From: Craig Shinkin <Craig@wellandidb.org.uk>
Sent: 10 March 2026 11:33
To: Chance, Jennifer
Cc: _planningadvice; HighwaysSUDsSupport; Jane Picking
Subject: H14-0065-26 (CS/JP/P/P/3b - Full) - Land off Farnborough Close, Pinchbeck, PE11 5AF

Planning Application: H14-0065-26 (Full – Erection of 40 dwellings, garages and associated infrastructure)

Figure 4 - Local IDB Features

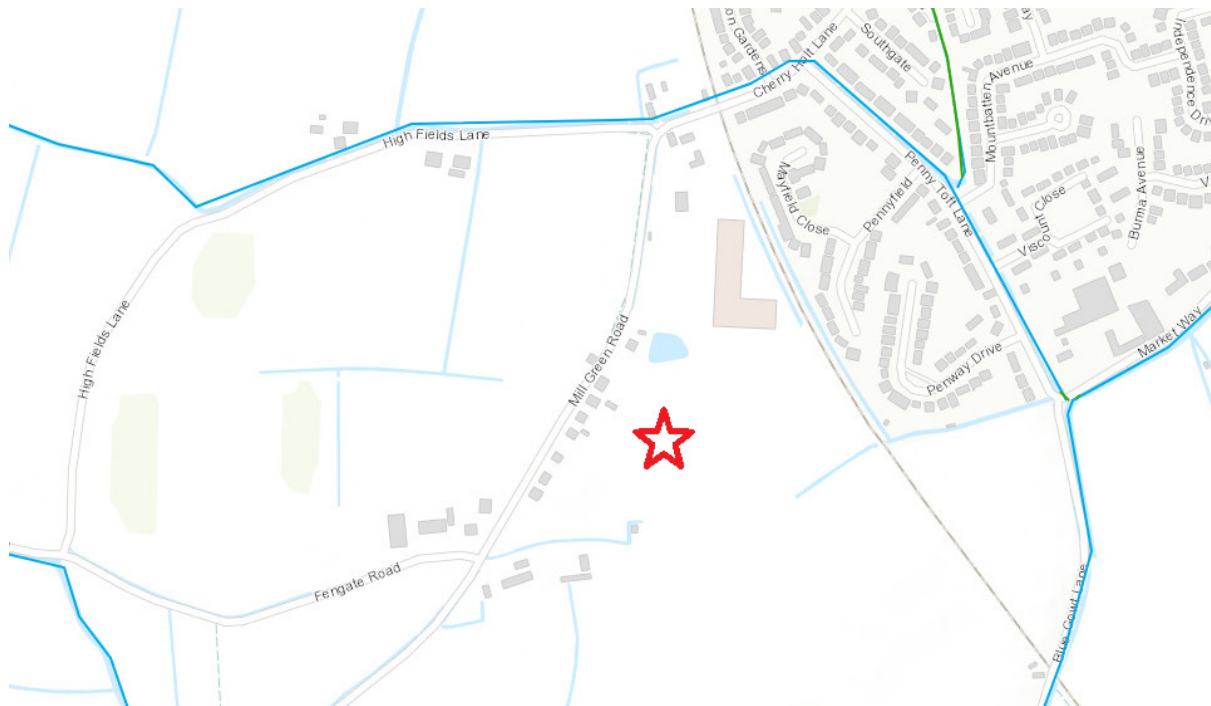
The applicant will need to prove that the route from the proposed surface water discharge outfall point through the riparian watercourse up until its entry into the Board's system is viable and fit for purpose to accept the attenuated discharge restricted to a maximum flow of 2.4 litres per second.

The receiving watercourse/pipeline will need to be cleaned out both upfront of connection and in perpetuity by the developer/their management company to reduce the potential for any issues and so that the site has a secure surface water outfall.

If this was agreed/proved then the Board would consider accepting the surface water from the site should planning permission be granted. This is subject to an application for consent to discharge water being made in advance of connection, which is subject to the agreement of technical details, payment of the application fee as well as payment of the relevant development contribution. The total proposed impermeable area to ultimately drain into the Board's system is to be confirmed to us.
